Office of Water

3 November 2011

Subject: OBERON TIMBER COMPLEX (DA27/95) – SECTION 75W MODIFICATION (MOD 5) – PUBLIC EXHIBITION OF ENVIRONMENTAL ASSESSMENT

## TYPICAL SWALE DETAIL SCALE 1:25

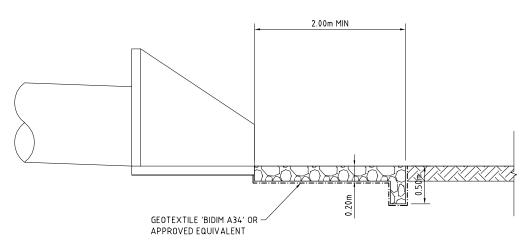
- The project includes a new swale on the western side of the proposed warehouse. The actual configuration of this swale is not clear with one section in the documentation proposing vegetated batters of 1:1 and another requiring a retaining wall on the building side. The Office of Water has significant concerns with the ability of vegetation to maintain stability of a 1:1 batter slope and the associated risk to channel stability and the proposed area of factory expansion. The proponent is therefore recommended to provide further justification on the use of vegetated batters for all proposed swales or consider alternative options to ensure stability. Confirmation is requested on the proposed design of Swale 1 and whether buffers are proposed. The Office of Water advocates the use of appropriately sized rock and vegetation to stabilise erodible or high velocity watercourse environments, and the use of box culverts over pipe culverts. The proponent is referred to the Office of Water's Controlled Activity Guidelines for further information at the following link: <http://www.water.nsw.gov.au/Water-Licensing/Approvals/Controlled-activities/default.aspx>

- The Office of Water will require detailed design for all infrastructure and works to be considered by a CAA in addition to supporting hydraulic and hydrologic studies. Details of scour protection at the outlets of culverts will be required, noting that concrete and rock gabions are not supported.
